CITY OF MERCER ISLAND

PROJECT NAME: PROJECT ADDRESS:

TOPOGRAPHIC & BOUNDARY SURVEY
PARCEL NO. 5458800550
LIU RESIDENCE
3705 77TH PL SE
MERCER ISLAND, WA 98040

A NEW HOME FOR:
THE LIU RESIDENCE
3705 11TH PL. SE
MERCER ISLAND, WA 98040

SITE PLAN

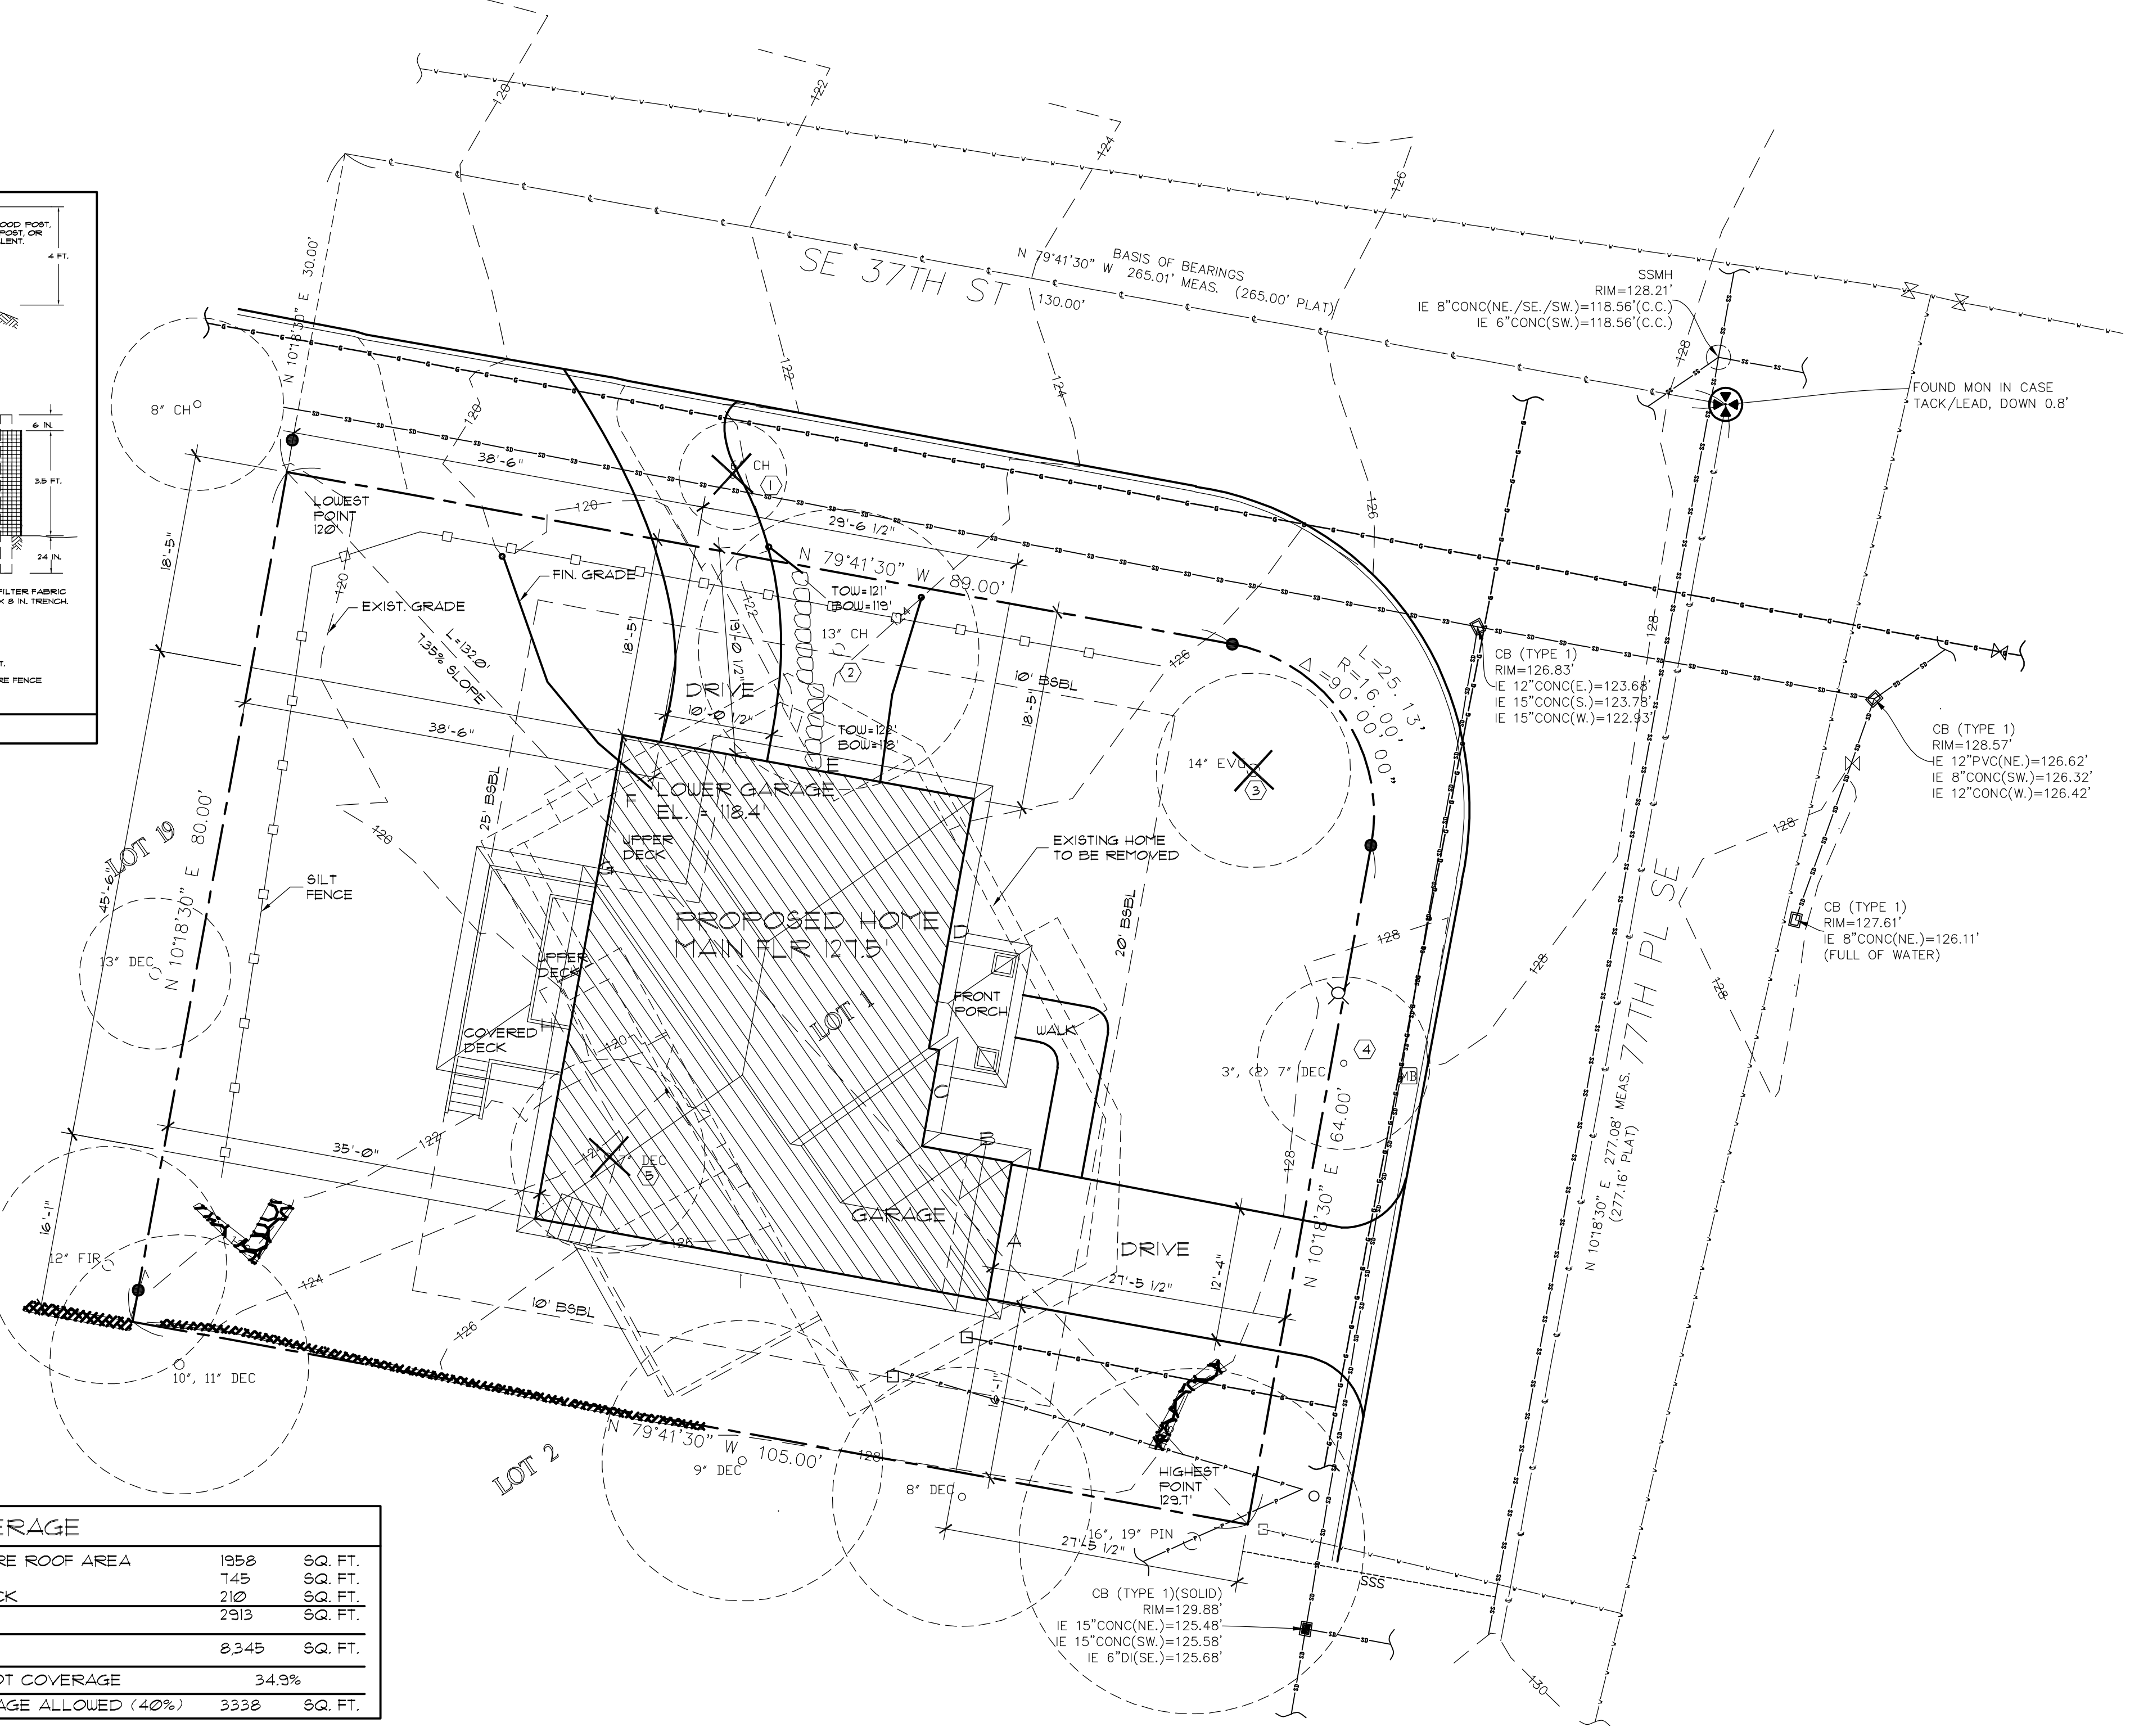
MICC 19.02.020(F)(3)(d) requires noxious weeds to be removed during new development proposals. Please add a note to the plan set that states:

"Development proposals for a new single-family home shall remove Japanese knotweed (*Polygonum cuspidatum*) and Regulated Class A, Regulated Class B, and Regulated Class C weeds identified on the King County Noxious Weed list, as amended, from required landscaping areas established pursuant to subsection 19.02.020(F)(3)(a). New landscaping associated with new single-family home shall not incorporate any weeds identified on the King County Noxious Weed list, as amended. Provided, that removal shall not be required if the removal will result in increased slope instability or risk of landslide or erosion."

Pursuant to MICC 19.02.050(D) any "...rockeries, retaining walls, fences, or any combination thereof, are limited to a maximum height of 42 inches within that portion of any required yard which lies within 20 feet of any improved street." Please indicate the height of the rock wall that falls within 20 feet of the public-right-of-way.

If the height exceeds the 42-inch height limitation you can apply for a fence height deviation pursuant to MICC 19.02.050(F).

Fence height deviation required for 4' retaining walls.
